Our Ref: STH09/01657/09
Contact: Amanda Priestley
Your Ref: SSD6277

STATE SIGNIFICANT DEVELOPMENT (SSD) 6277 – JUPITER WIND FARM

Roads and Maritime Services (RMS) refers to your letter dated 29th November 2016 regarding the subject SSD.

Figure 3.2: Project Area Layout and Vehicle Access Locations

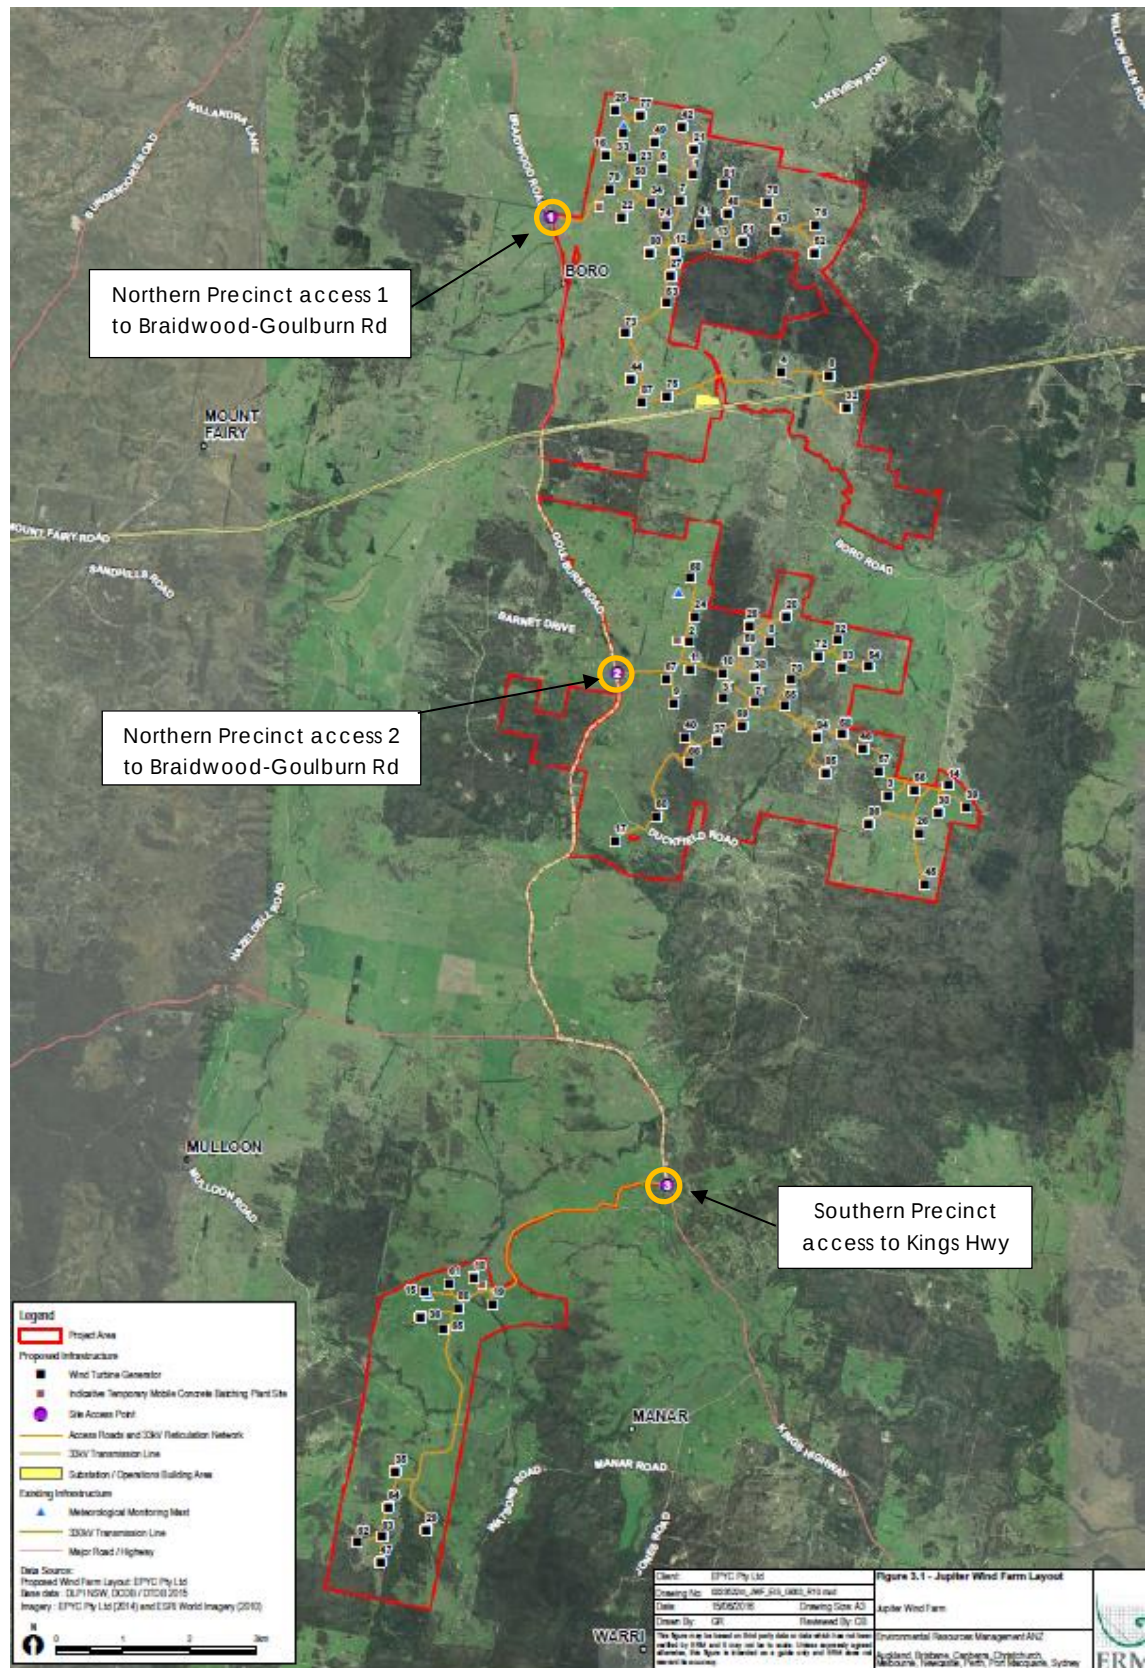
- RMS requires sight distance measurements for each access, provided as measurements, not pictures alone. It needs to be clearly demonstrated that the sight distance requirements, in accordance with *AUSTROADS Guide to Road Design – Part 4a: Unsignalised and Signalised Intersections* Table 3.2, are met.

Figure 4.12: Warrants for Turn Treatments on Major Road

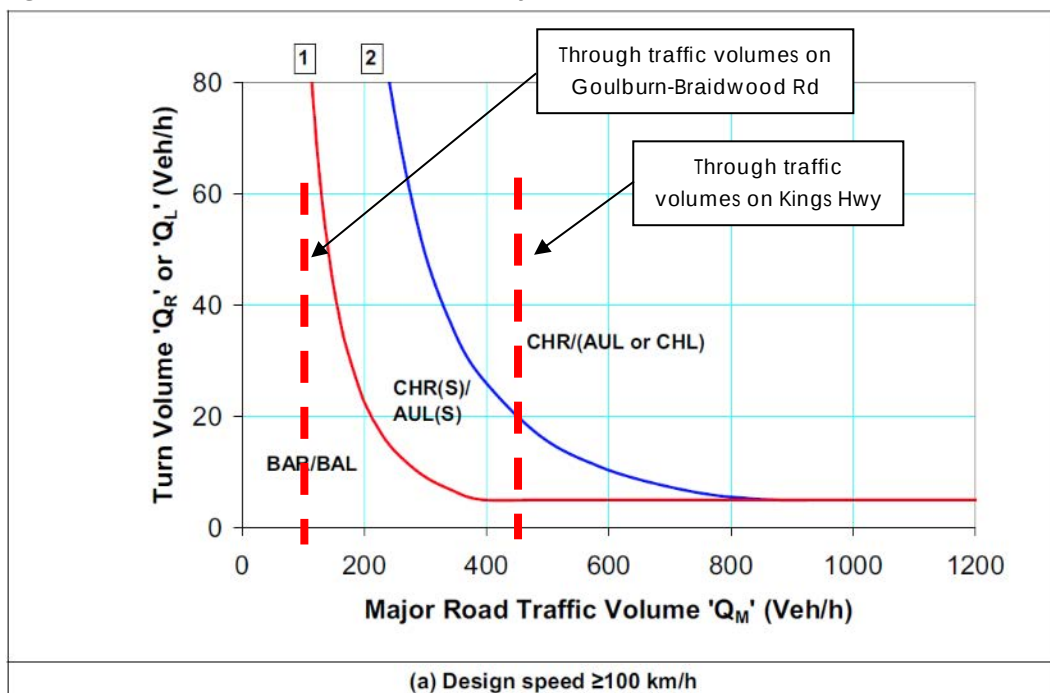
- RMS have reviewed the turn warrants (section 4.5.3 from the 'Transport Impact Assessment') and require clarification and justification of the figures used.
